Application No: Y/29/21/HH
Site Address: Magnolias Church Lane Yapton BN18 0EH
Description of works: Erection of double garage.

YPC have considered this application and object on the following grounds:

project			
MAGNOLIAS CHURCH LANE YAPTON ARUNDEL BN18 0EH			
drawing title			
PROPOSED GARAGE BLOCK PLAN			
date			
11/01/2021	scale	1:500 @ A1	
job no.	drg. no.	rev	
JA-MAG-02	01	A

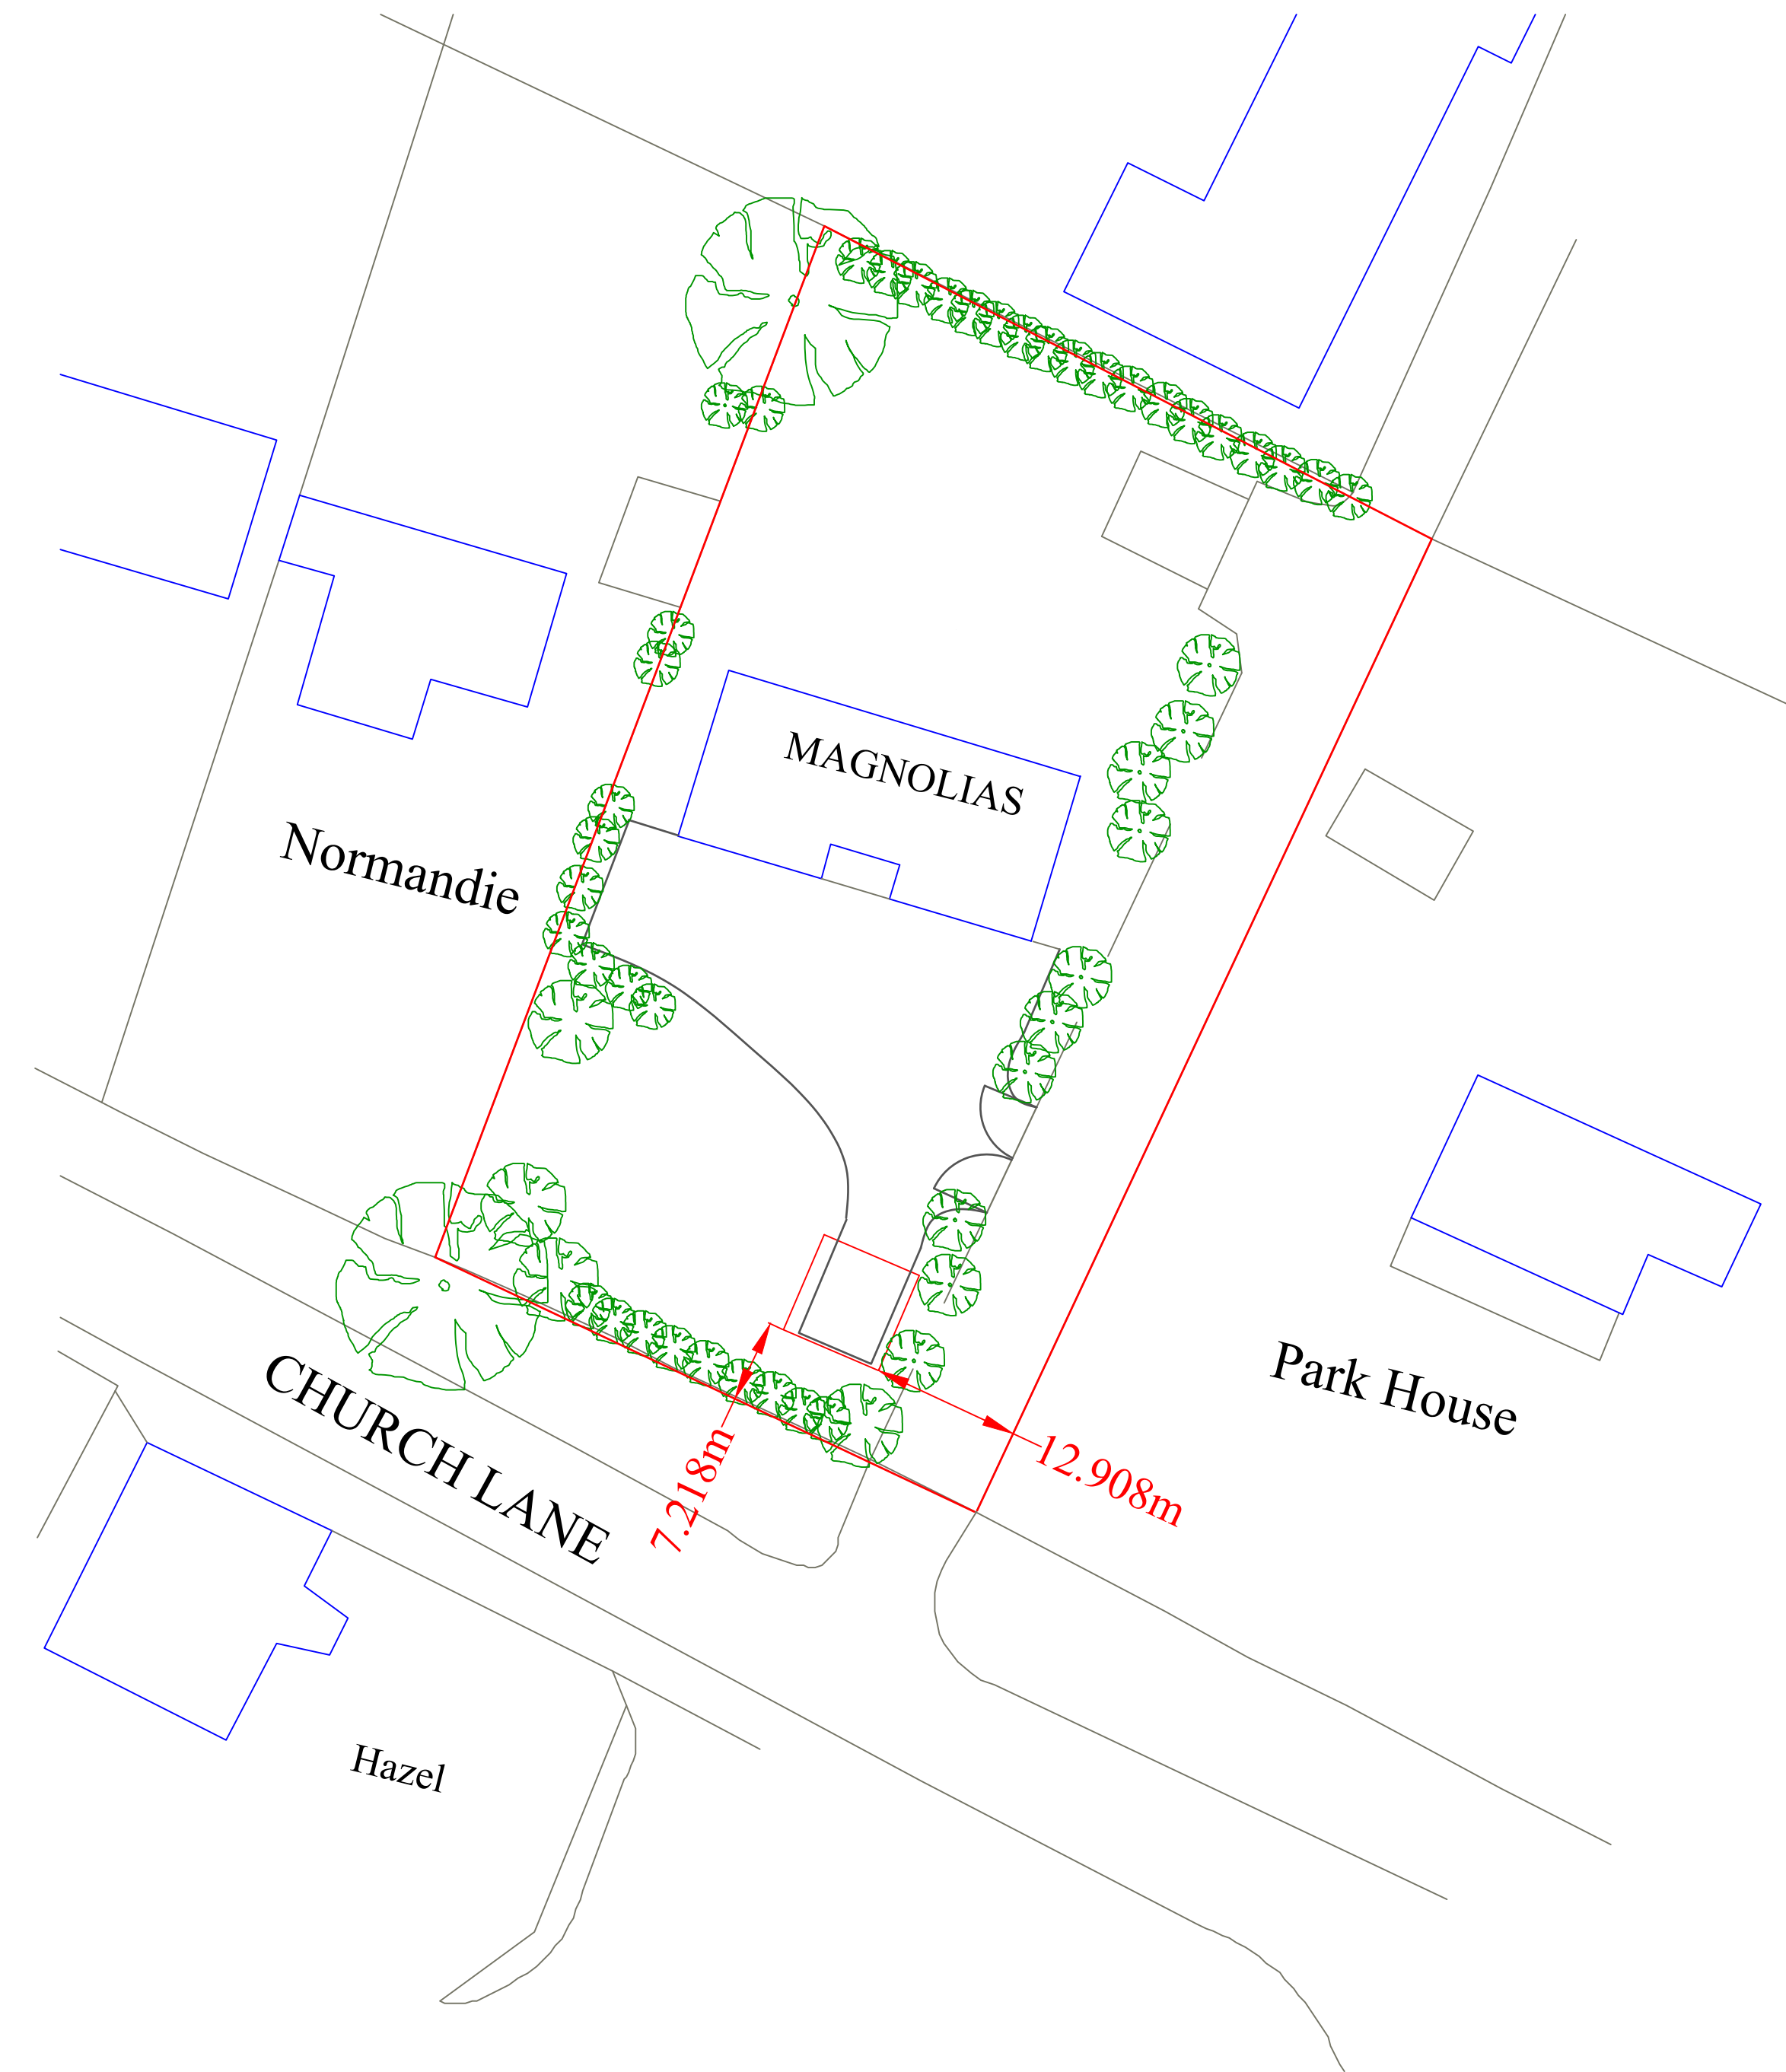
- YPC note that the proposed unit encroaches a clearly set and established building line that runs along the northern side of Church Lane. YPC is strongly against this building line being broken as it maintains the integrity of the overall Church Lane street scene and setting to the adjacent conservation area.
- The height of the unit is also out of keeping with Church Lane. The overall impact of the height is further compounded by the nature of the levels of the land along the northern stretch of Church Lane which is significantly raised compared to the southern side. YPC would expect a single storey unit only.
- YPC note that previous planning history objected to a garage located in this location as over development for the plot. YPC note that there has not been any significant material changes to the plot to counter these grounds of concern/objection.
